From: Martyn White <Martyn.White@arun.gov.uk>
Sent: 22 January 2020 15:04
To: Planning.Responses <Planning.Responses@arun.gov.uk>
Cc: Finlay Gardner <Finlay.Gardner@arun.gov.uk>
Subject: BE/113/19/HH

BE/113/19/HH

The proposal consists of two elements: alterations to a boundary wall to the rear of the site and a first-floor extension.

sheet 2 of 5

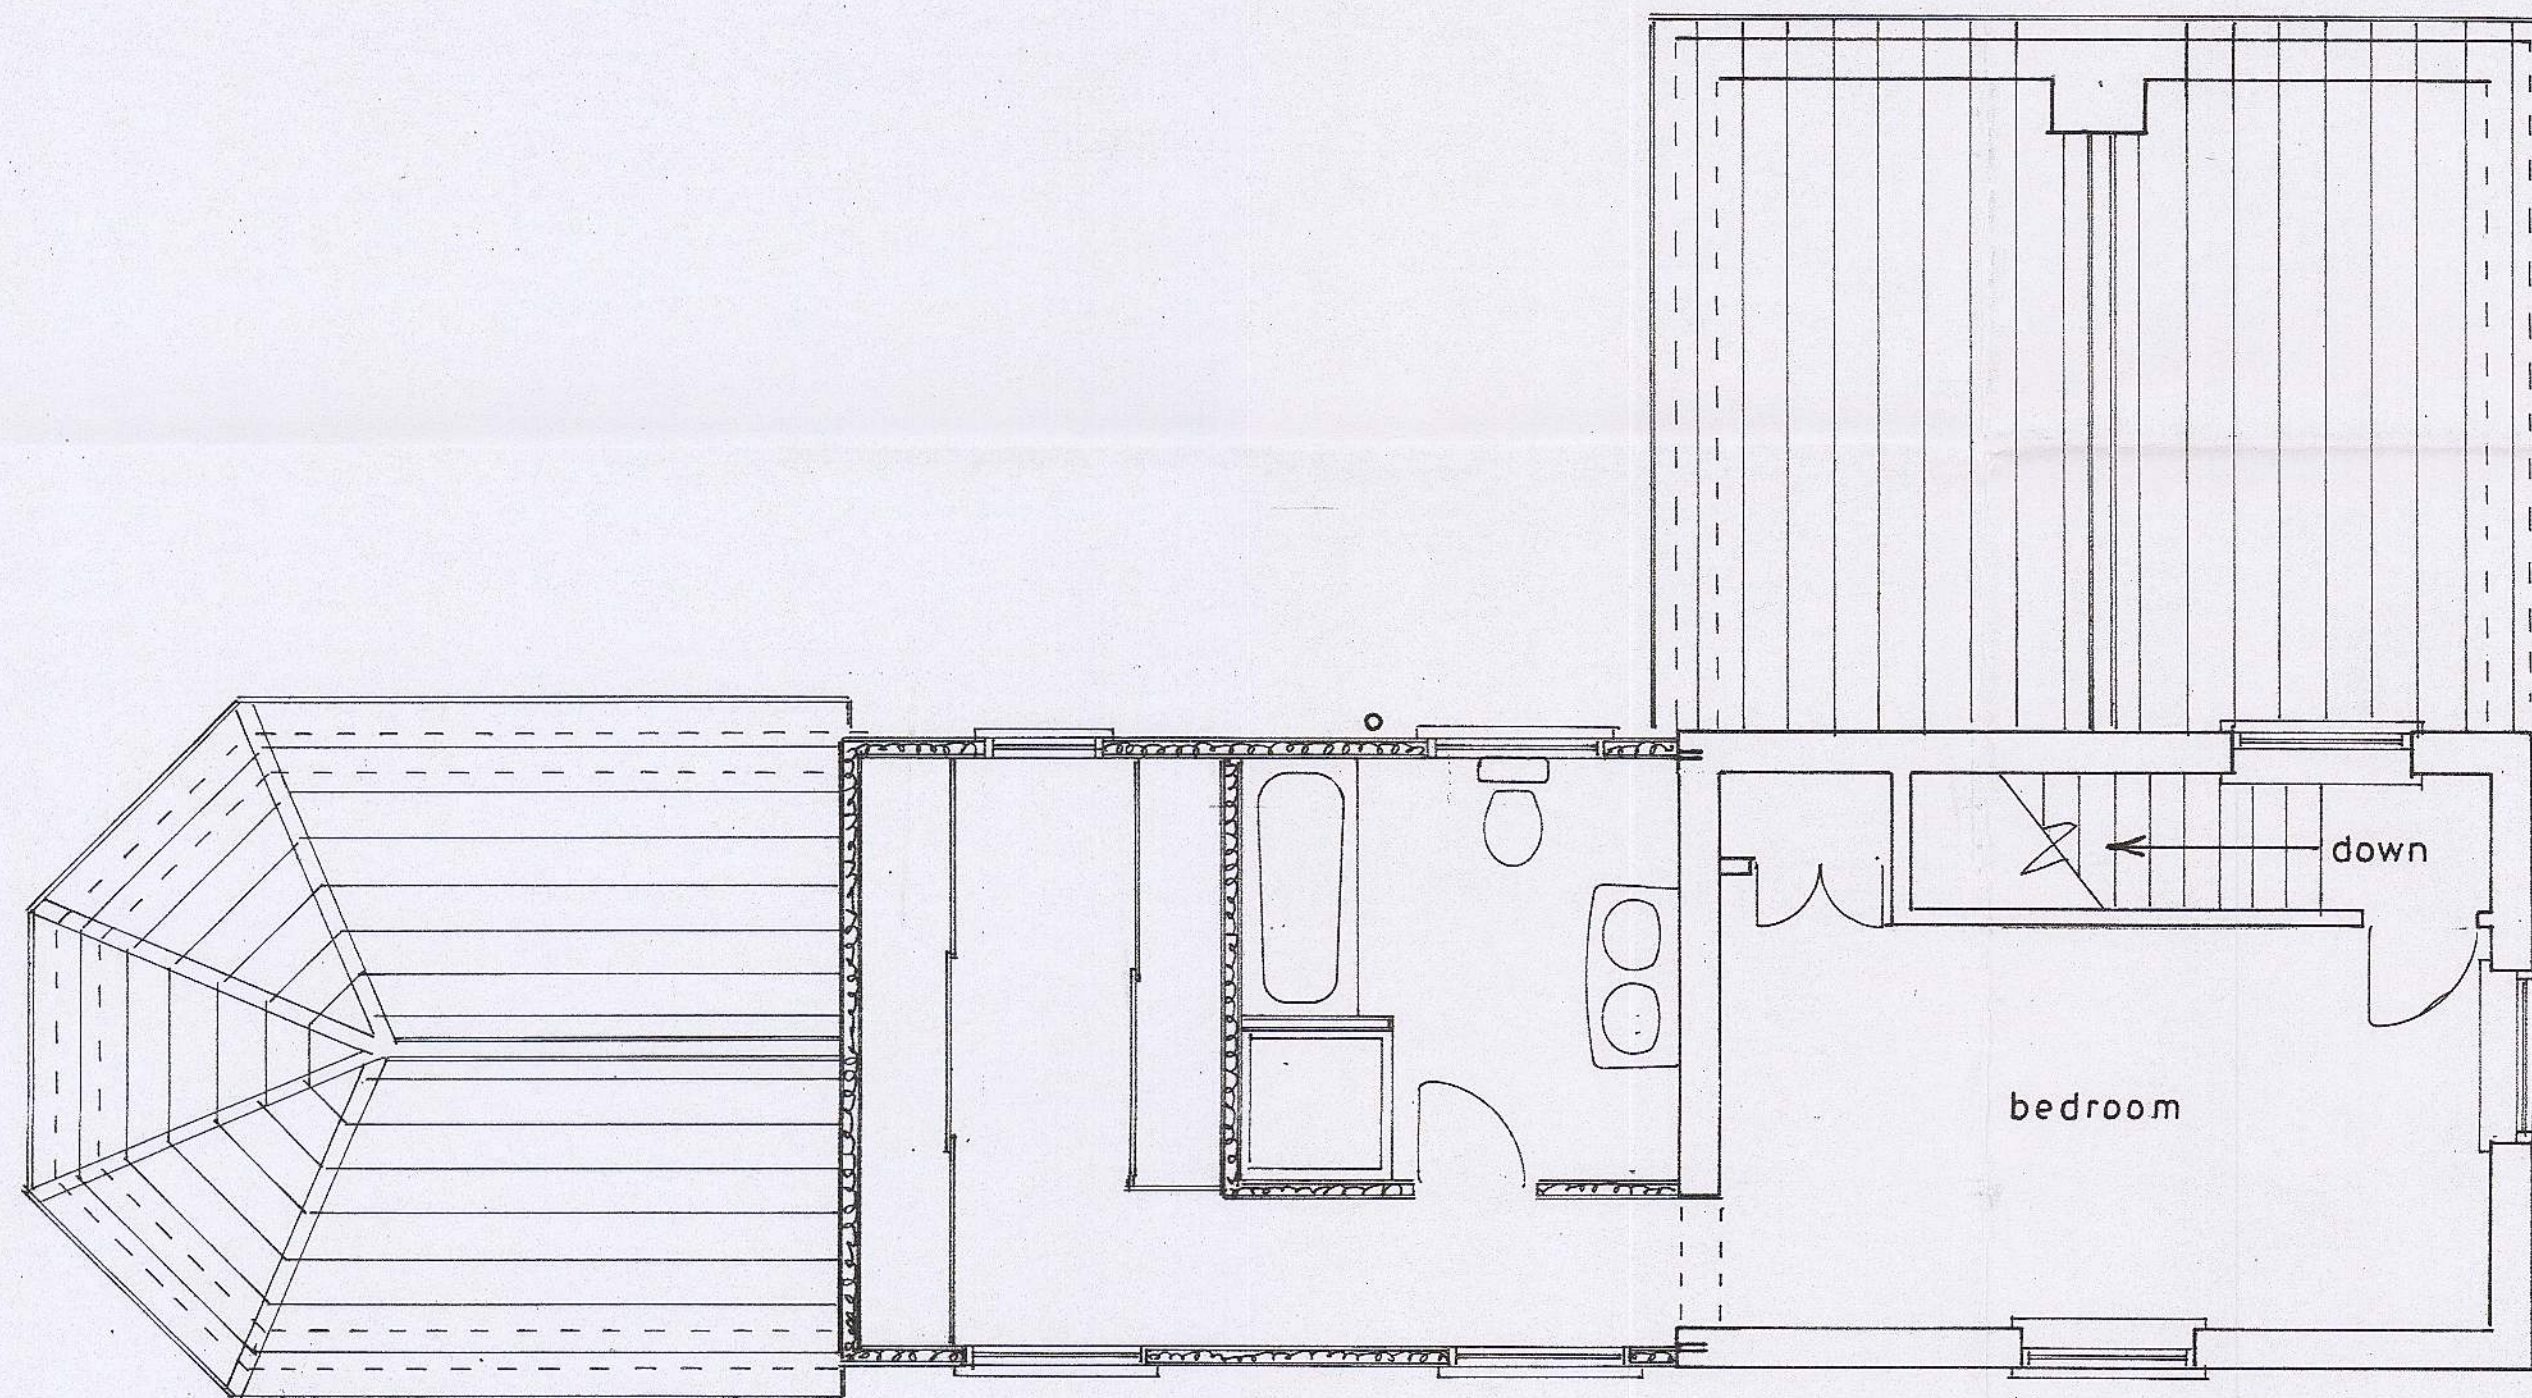
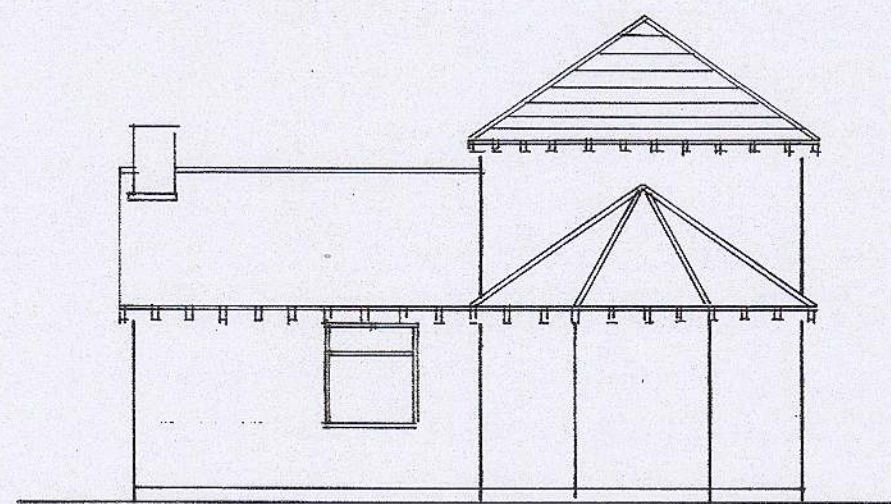
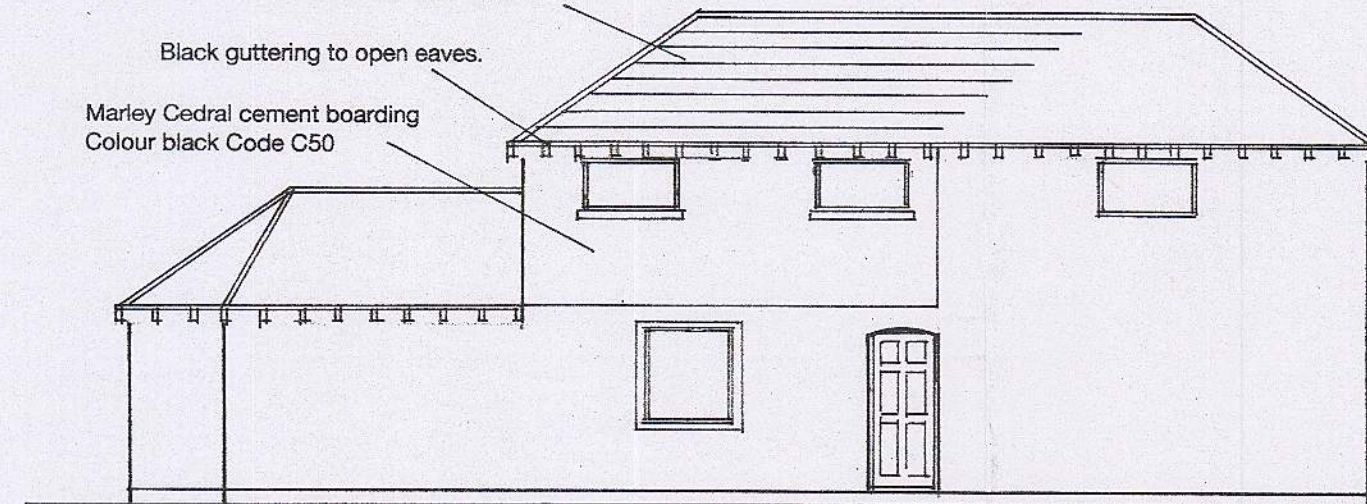
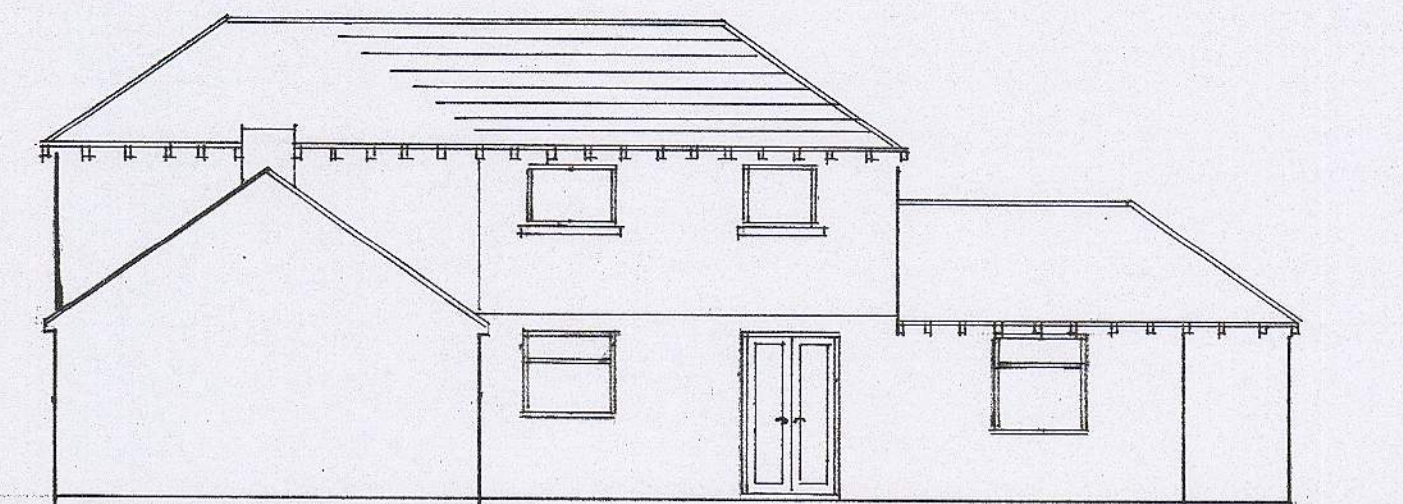
In contrast, the first-floor alteration is problematic. At present, the existing building is considered to sit very close to the listed building and has an impact upon how it is seen/experienced. It already causes a level of harm that is unfortunate. However, the proposal will extend the first-floor area closer to the road, and therefore much more into the view of the listed building. Such an alteration will therefore be visually dominant and harmful to the setting of the listed building.

The proposal is such that the impact can be described as causing less than substantial harm in accordance with paragraph 196 of the NPPF (2018). As such, you will also need to consider the public benefits that the development may achieve as part of your assessment of the application, along with the contents of the Planning (Listed Buildings and Conservation Areas) Act 1990 (as amended).

sheet 5 of 5

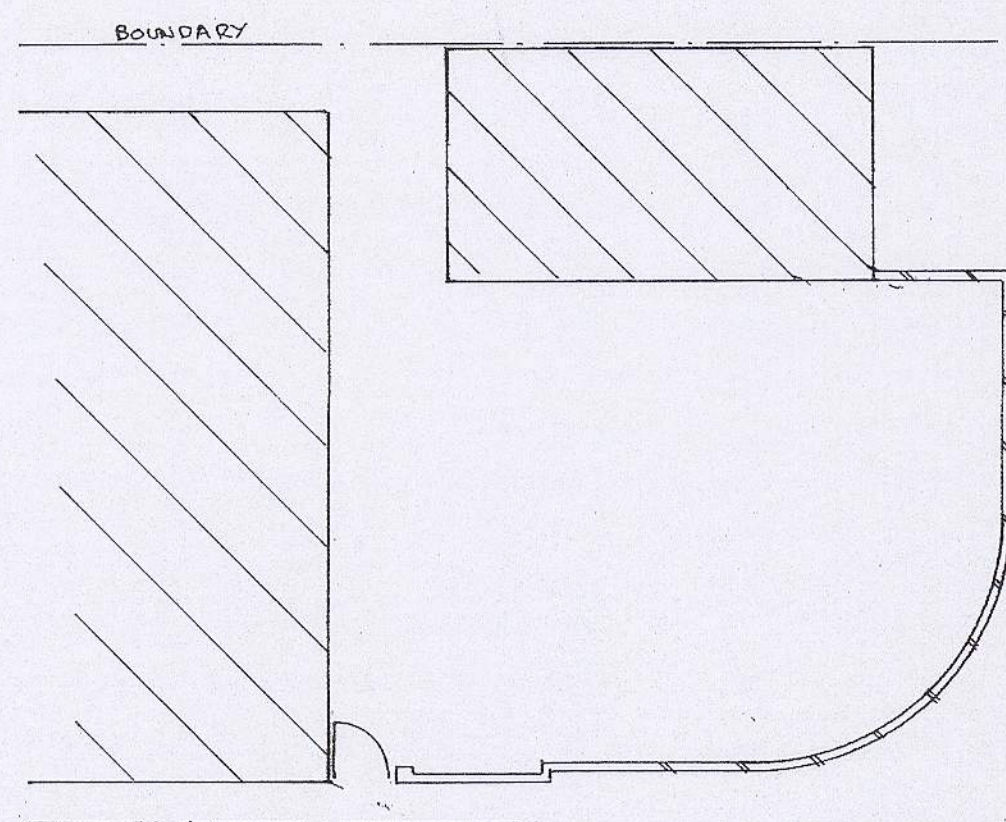
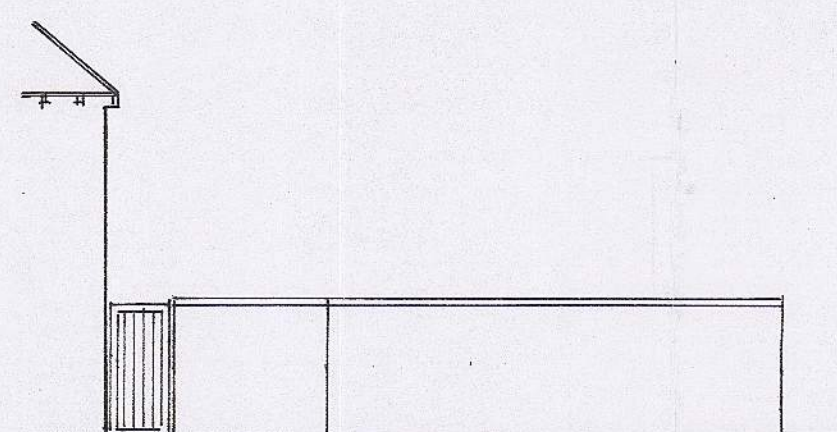
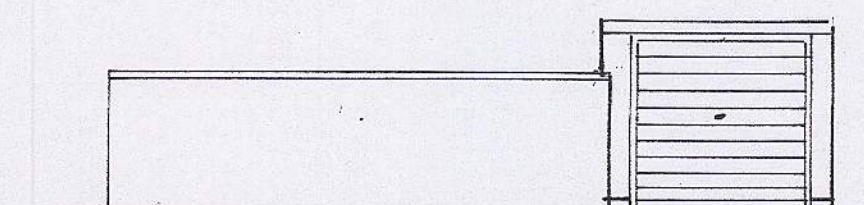
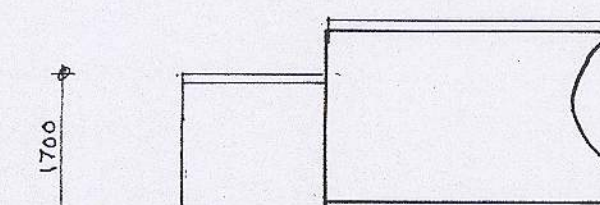
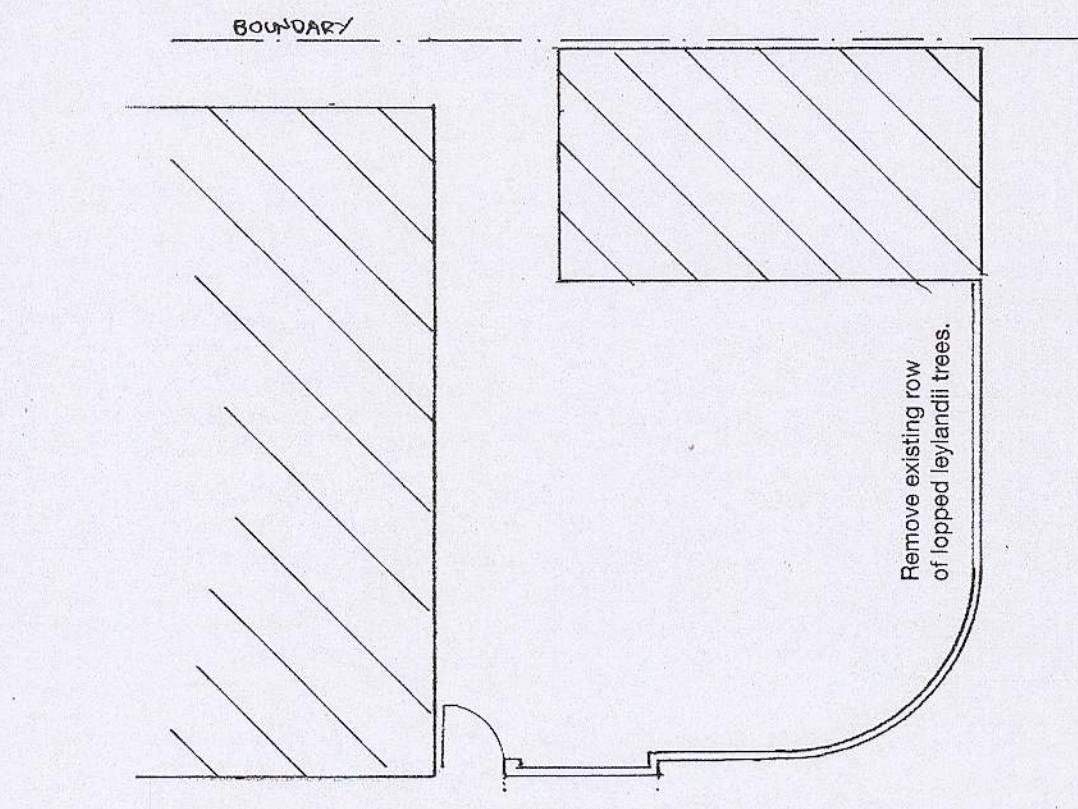
It would appear that the proposed alterations to the boundary walling would result in the loss of a leylandii hedge. Whilst it is unfortunate that there would be a loss of some greenery in this location, it will not unduly harm the character of the small road it is facing, or the local area.
